DEVELOPMENT REVIEW BOARD
TRANSPORTATION DEVELOPMENT

DRB Project Number: 1000111
Altura Complex

SUBJECT: Preliminary/ Final Plat

PLAT OF TRACT B1 AND B2 ALTURA COMPLEX WITHIN SECTION 11, TOWNSHIP 10 NORTH, RANGE 3 EAST, NEW MEXICO PRINCIPAL MERIDIAN CITY OF ALBUQUERQUE BERNALILLO COUNTY, NEW MEXICO JULY 2018

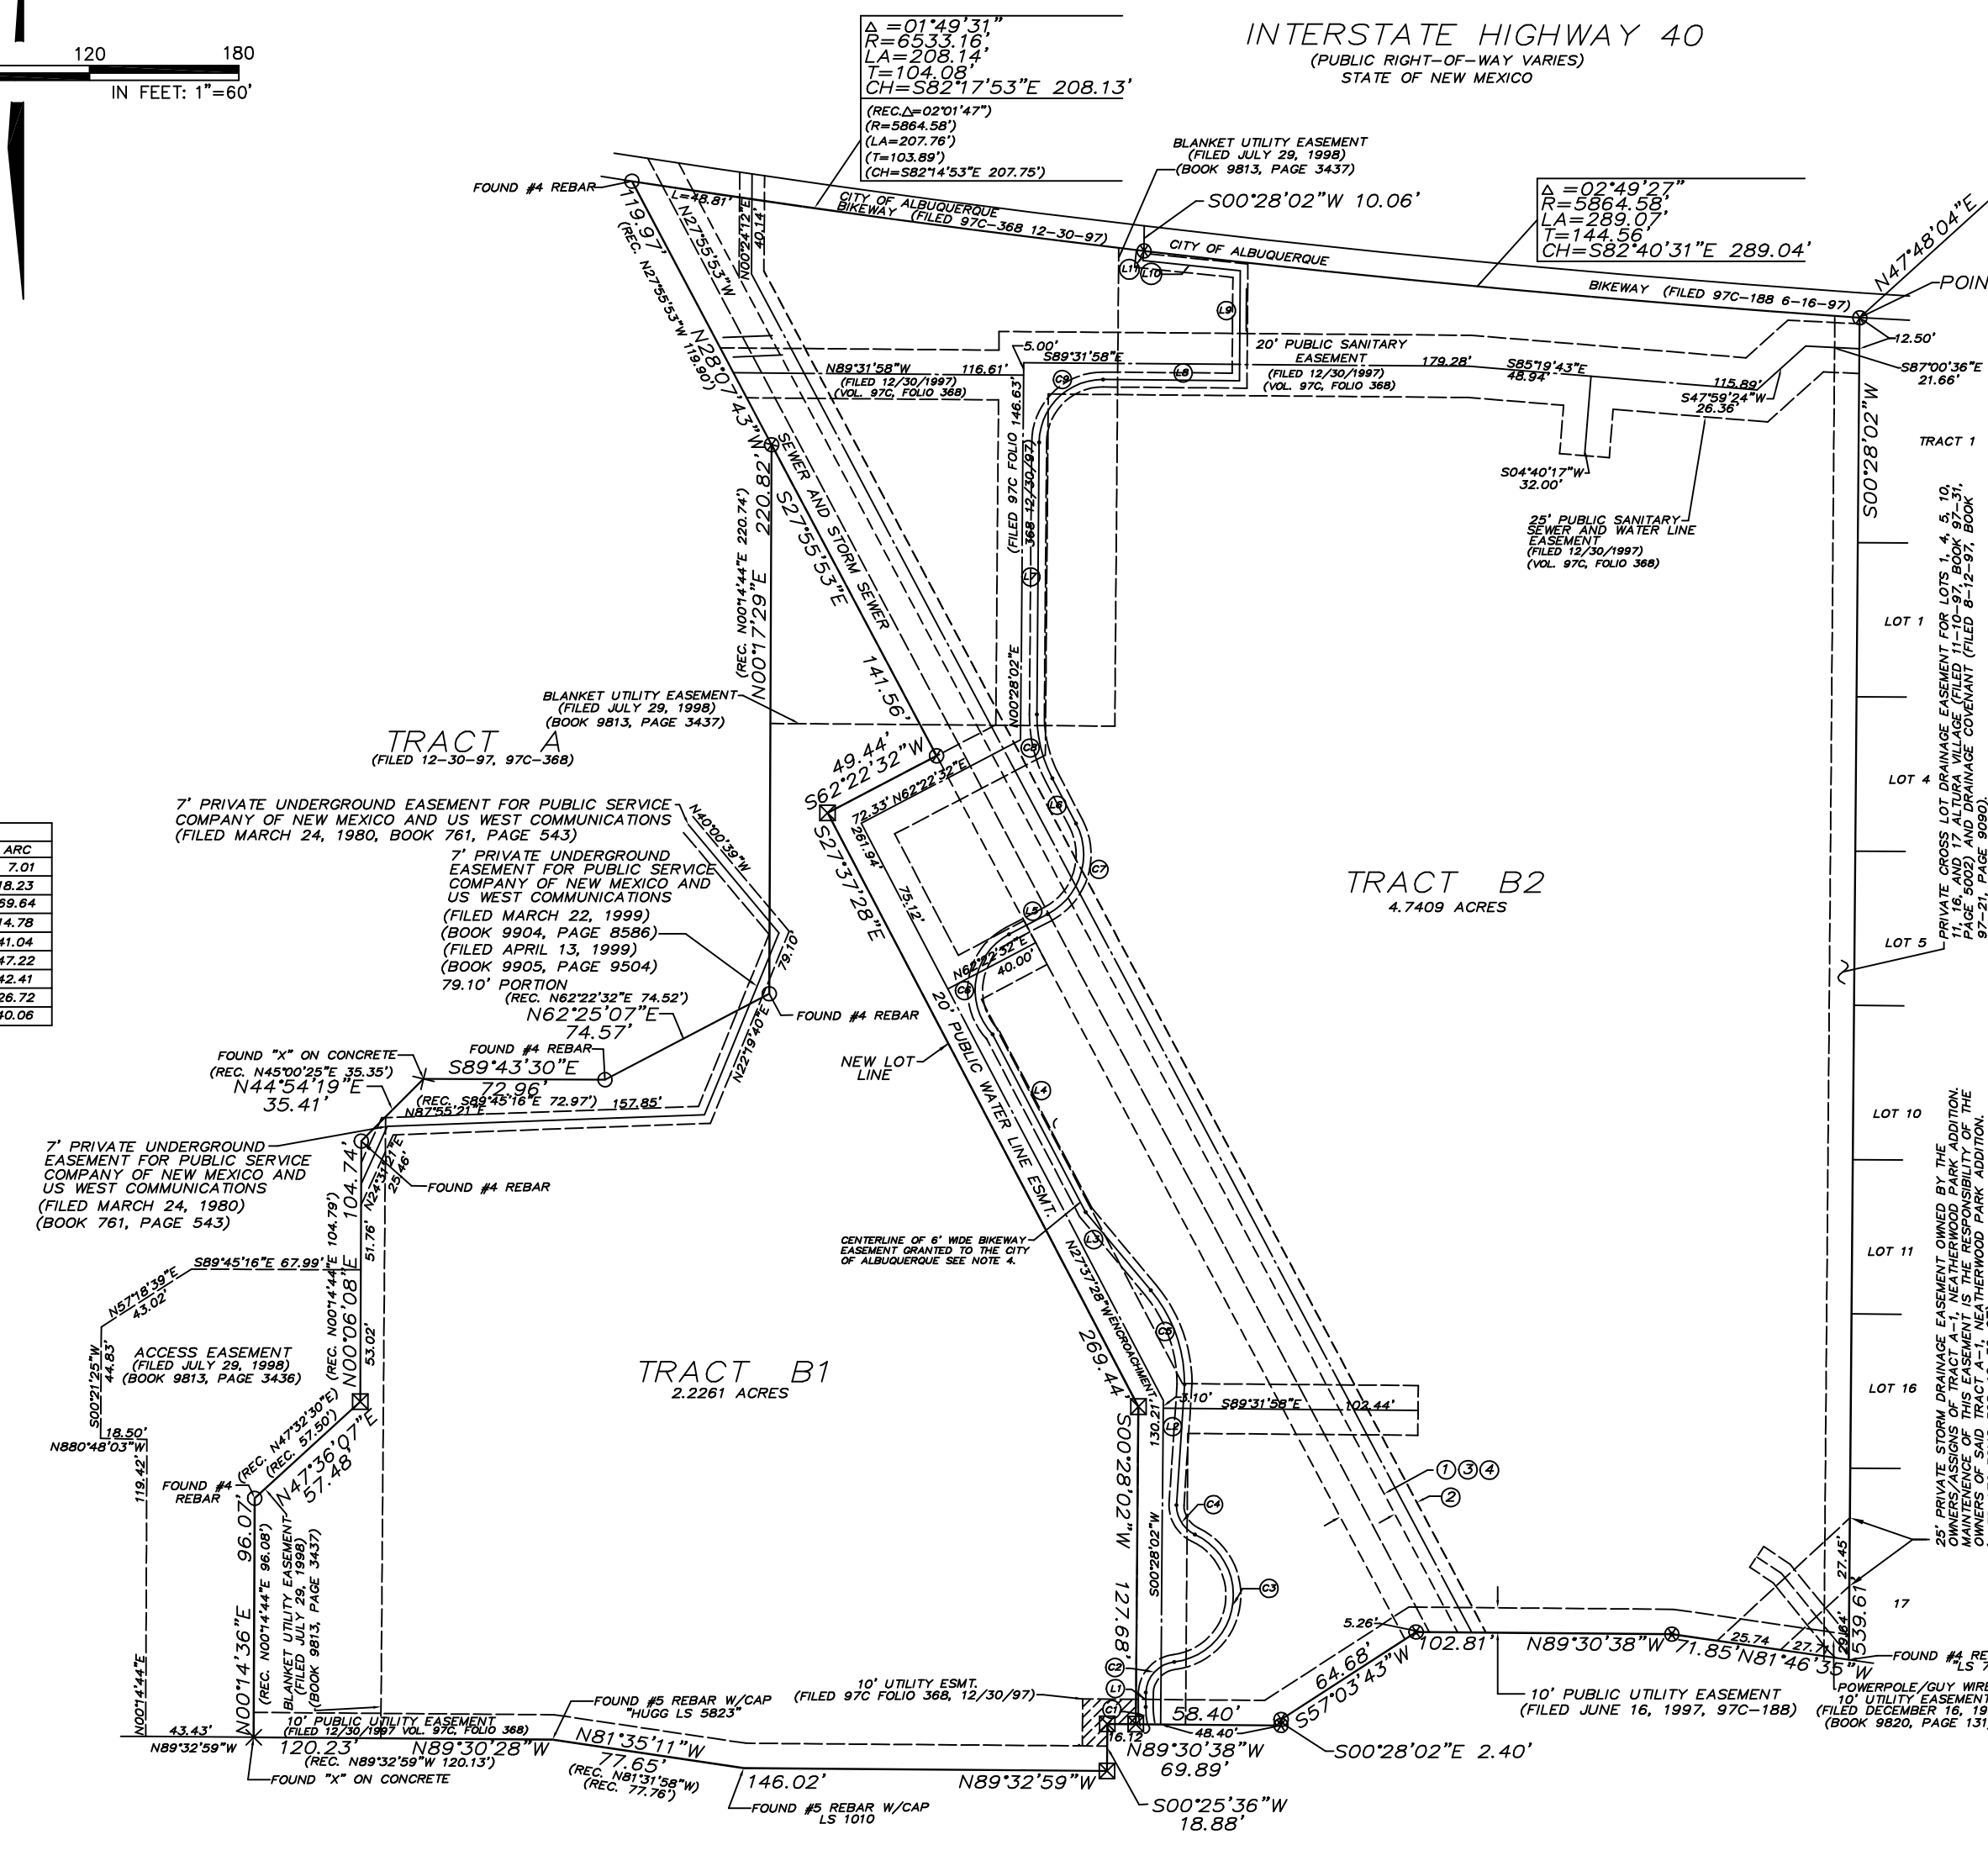
1. Provide a reciprocal shared access easement for lots B1 and B2
2. For final plat, any access easements need to be shown with all beneficiaries and maintenance responsibilities listed.
